Project Title: Creekside West Subdivision

Re: Grading and Drainage Approval for Final Plat on Creekside West (L-23/D17)

RE: SITE DEVELOPMENT PLAN APPROVAL FOR CREEKSIDE WEST SUBDIVISION (L-23/D17)
ENGINEER'S STAMP DATED 12/23/93

TITLE: CREEKSIDE WEST SUBDIVISION
GRADING AND DRAINAGE PLAN

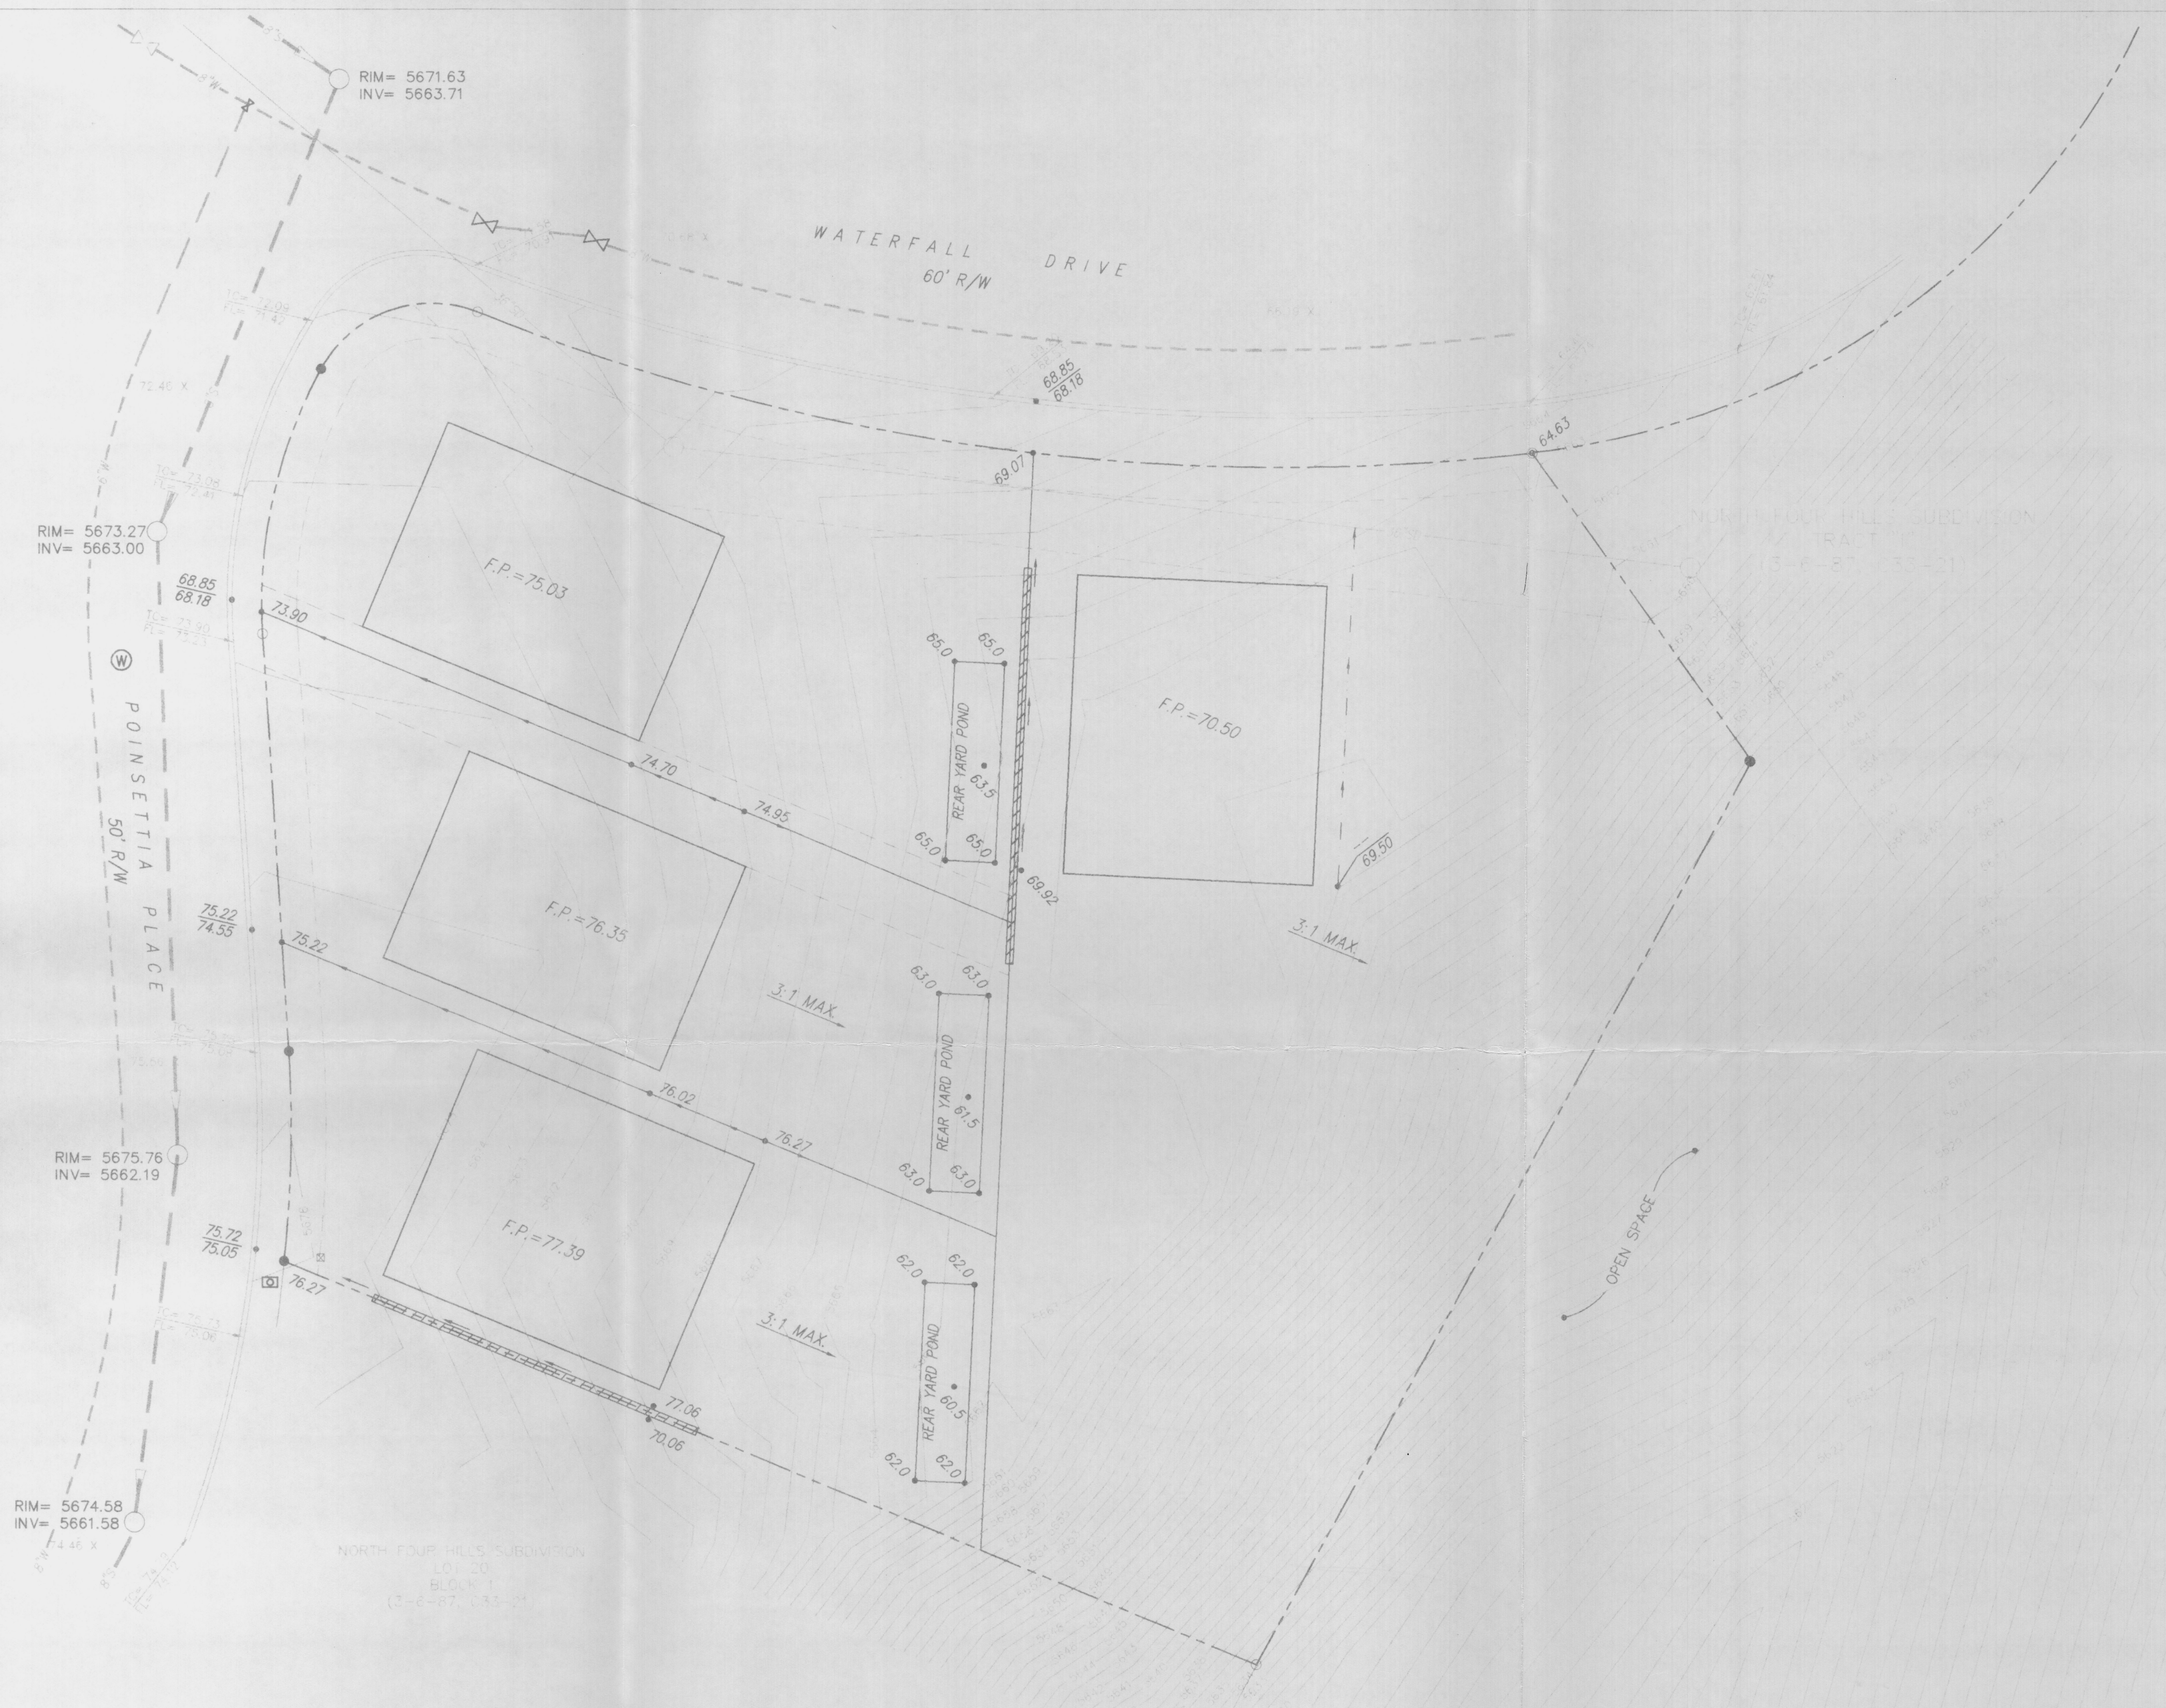
1. How do you propose to ensure that future property owners will maintain the intended rear yard drainage pattern including the ponds themselves?
2. The existing storm drain easement along Waterfall Drive needs to be clearly labeled.

3. You mention that everything except the back yards will drain to the street on lots 1-3. Is this also the case for the other lot adjacent to the Open Space (roof drains to front)?

4. Additional proposed elevations are needed along the rear of the lots with the backyard ponds. I am concerned that there is sufficient elevation differential to ensure that water does not leave the ponding area and impact the adjacent lot and Open Space area. As shown on your plan, the southernmost lot has a definite problem.

5. Driveway locations need to be shown.
6. On the lot adjacent to the Open Space, how do you propose to ensure that future lot owners will not alter or make additions which would concentrate flows to the Open Space area?

1. A statement preventing owners from altering the configuration and character of their backyard ponds has been added to the plan (note 8).
2. The existing storm drain and its easement along Waterfall Drive now appears more clearly on the drawing.
3. All side and front yards on all of the lots within this subdivision will drain toward the street, including Lot 4.
4. Proposed elevations have been located along the property line adjacent to these ponds. At least 12 inches additional freeboard now exists between the pond water surface and the grade along the property line.
5. All driveways are now shown on the plan.
6. Note 8 has been added to the plan to ensure the grading scheme will not be compromised.

TITLE: CREEKSIDE WEST SUBDIVISION
GRADING AND DRAINAGE PLAN

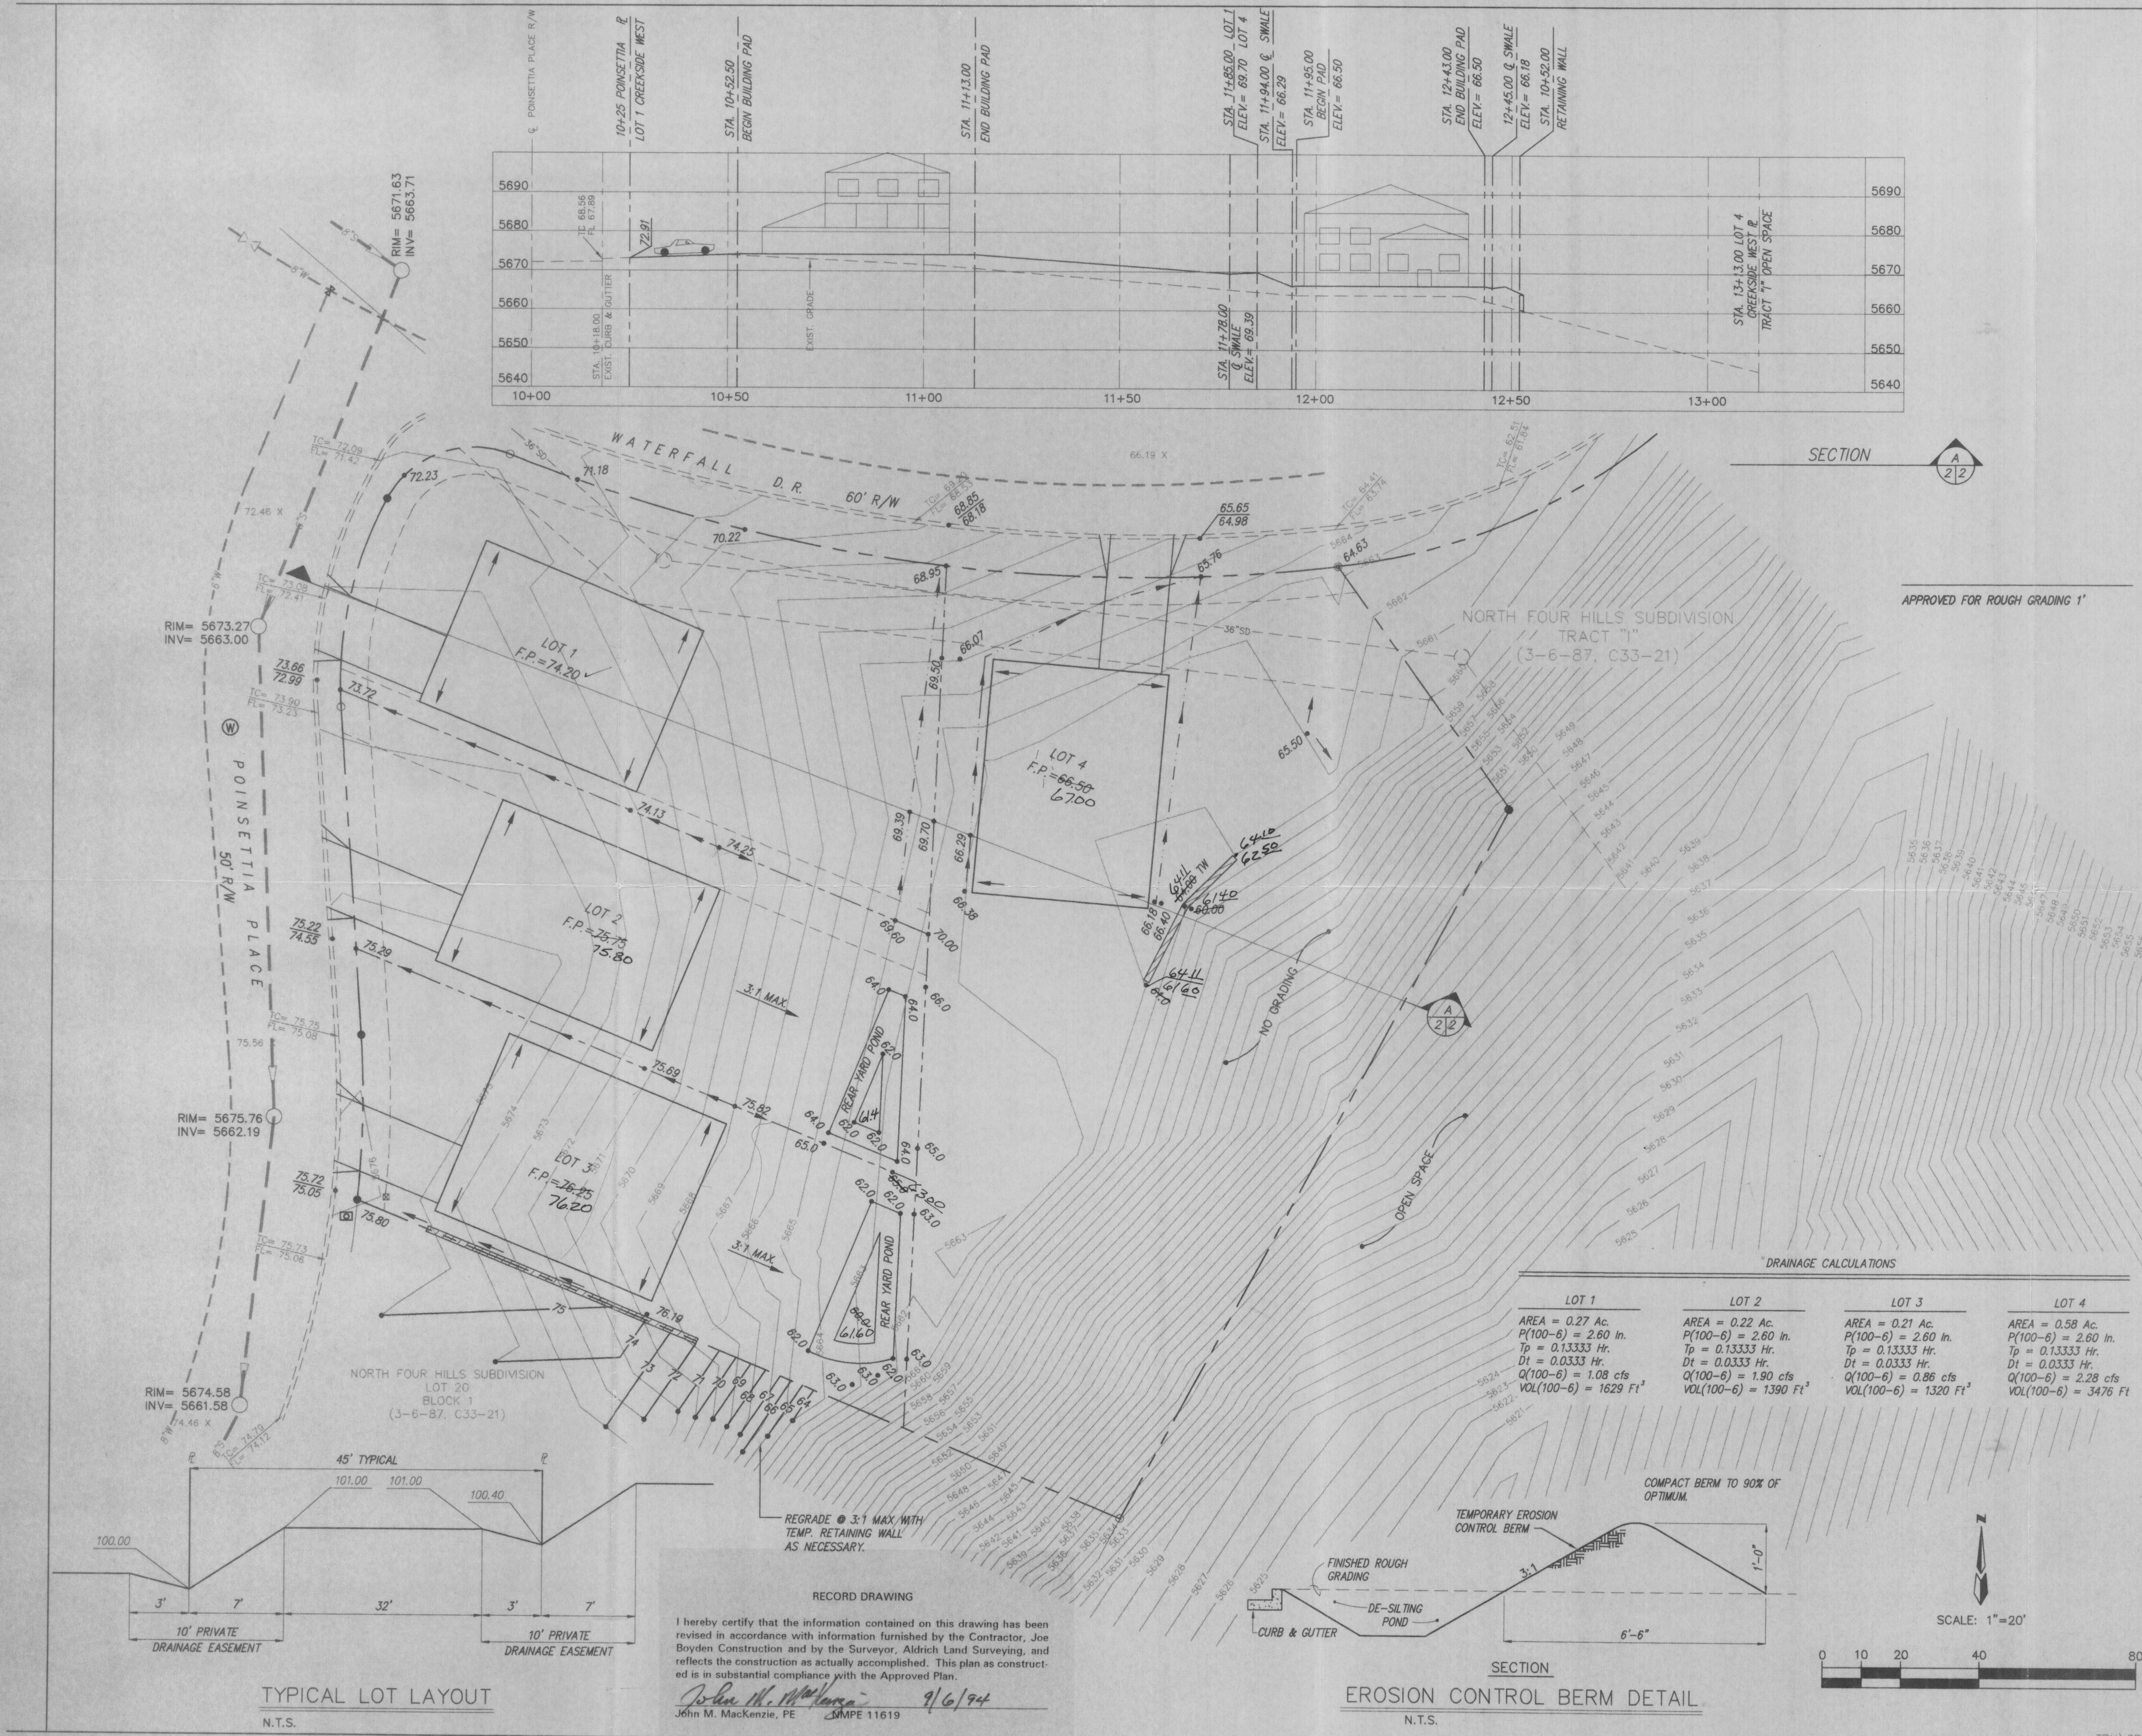
Engr. will resubmit
after southerly pond
is graded to acceptable
depth.
